Recommendation Report for Planning Permission for Works or Extension to a Dwelling

REF NO: AW/31/21/HH

LOCATION: 3 Haydon Close
Aldwick
PO21 4LG

PROPOSAL: Single storey rear extension and front porch

Mr. & Mrs. Vitanyi
3 Haydon Close, Bognor Regis
West Sussex PO21 4LG
PROPOSED ELEVATIONS
Date: JAN 2021 Scale 1:100 Dw no. PR.EL 06

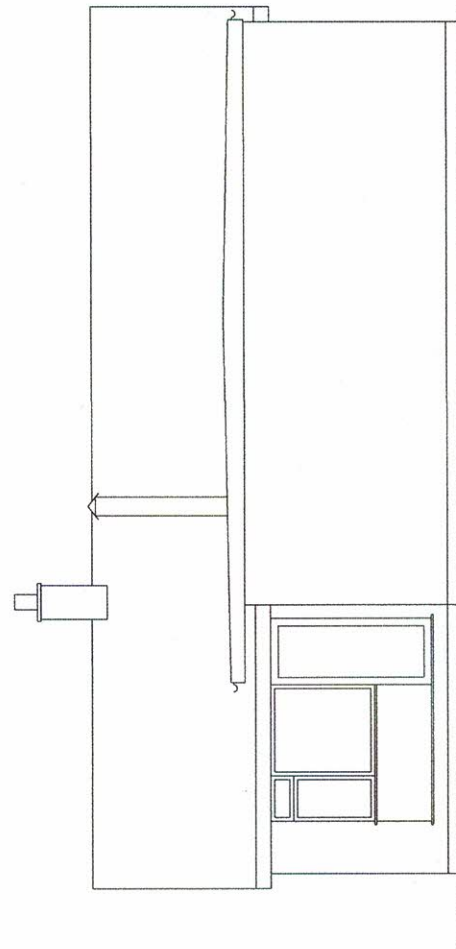
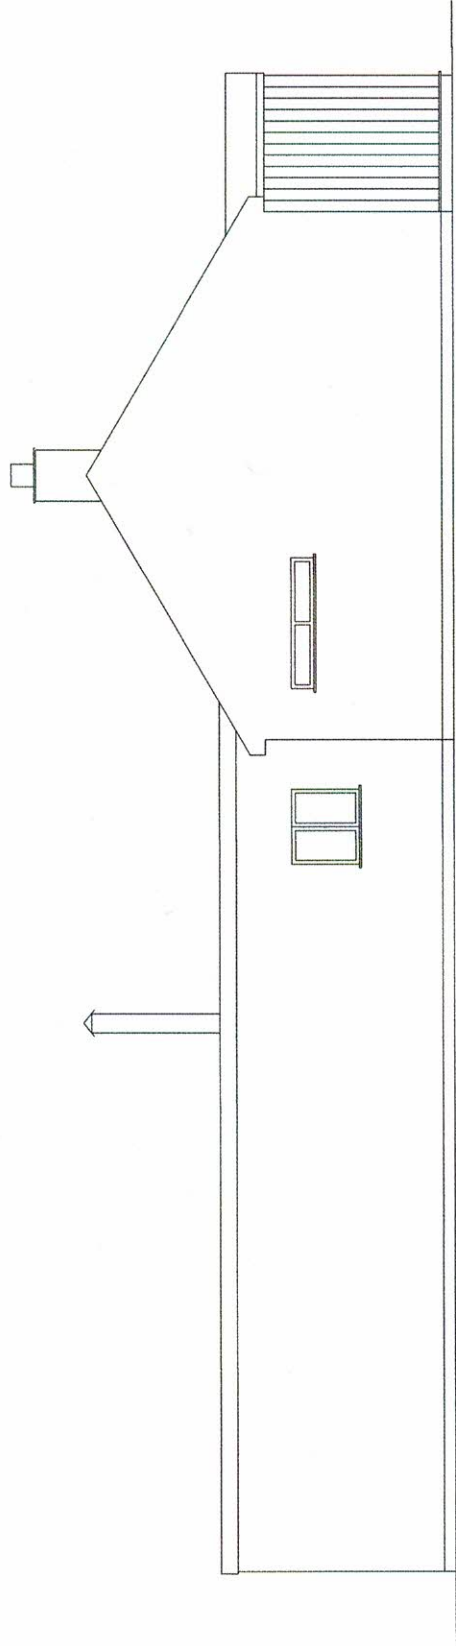
The design of the rear extension is to incorporate materials which are currently present on site. There are 2 expansive elevations to the North and East, without Interruptions these elevations are deemed unsympathetic and uncharacteristic and overly dominate on the host dwelling which is in conflict with policy D DM4 of the Arun Local Plan or Arun's Design Guide.

As stated above, the extension runs 1m away from the Northern boundary and a portion of the Eastern boundary. The extension's overall height is approximately 3.2m, over 1m higher than the fence lines to the rear gardens.

The property to the East at No. 37 Pryors Lane has a relatively short rear garden at approximately 8m in depth. Given the additional height of the proposal, which runs in close proximity to the boundaries, and the short depth of the rear garden to No. 37 Pryors Lane it is considered that without interruption, this excessive bulk is overbearing on the neighbouring properties to the North and to a lesser extent the East. When considering the 45-degree rule, the proposed extension would extend past a point considered acceptable.

In terms of overshadowing, the length and positioning of the extension against the Northern boundary will create additional shading of the entire length of the rear garden of No. 4 Haydon Close. The effect of this along the length of the boundary is thought to be an unneighbourly form of development.

PROPOSED FLOORPLANS

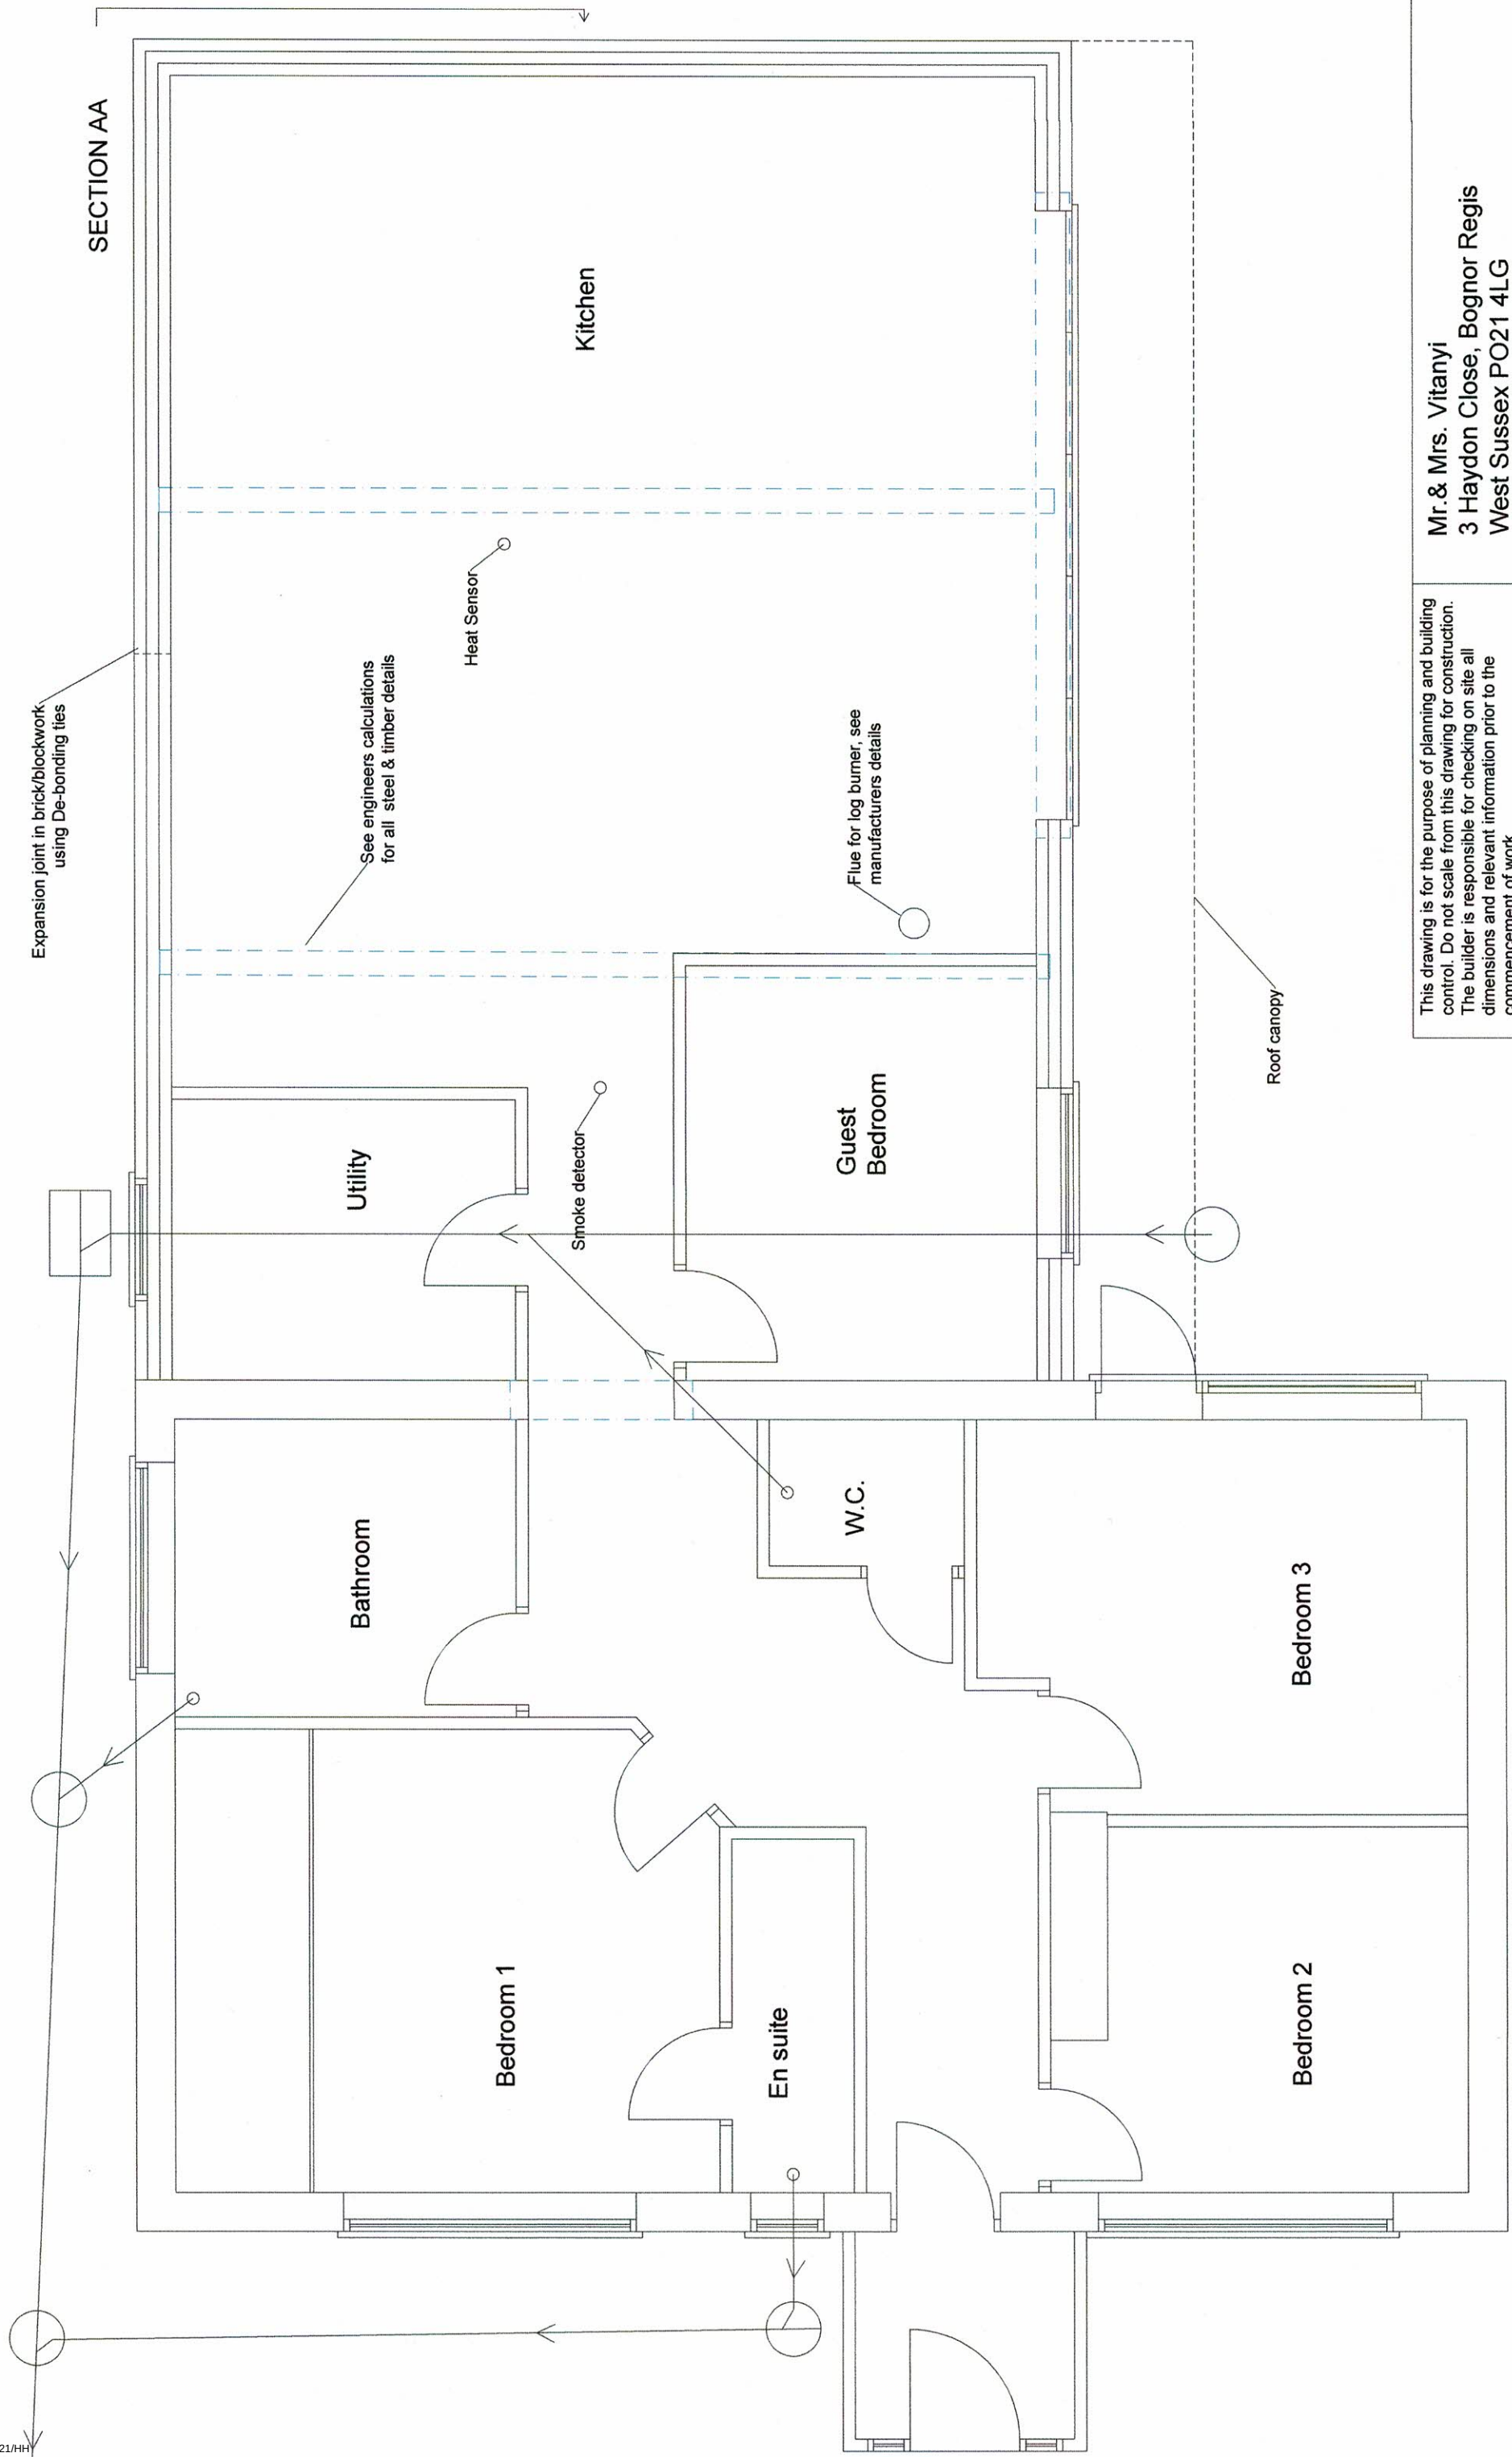
It is proposed to build the rear extension running 1m away from the Northern and Eastern boundaries of the site and the proposal consists of a large footprint increase of over 100% of the dwelling. Current guidance with the Local Plan and Arun Design Guide states that extension over 50% increase of floor space will be considered disproportionate and are unlikely to be acceptable, although it is noted that this property has the benefit of a slightly larger rear/side garden when compared with its neighbours.

Given its disproportionate scale and lack of visual integration, it is considered the extension does not accord with D DM4 and the Arun Design Guide by means of its excessive footprint increase.
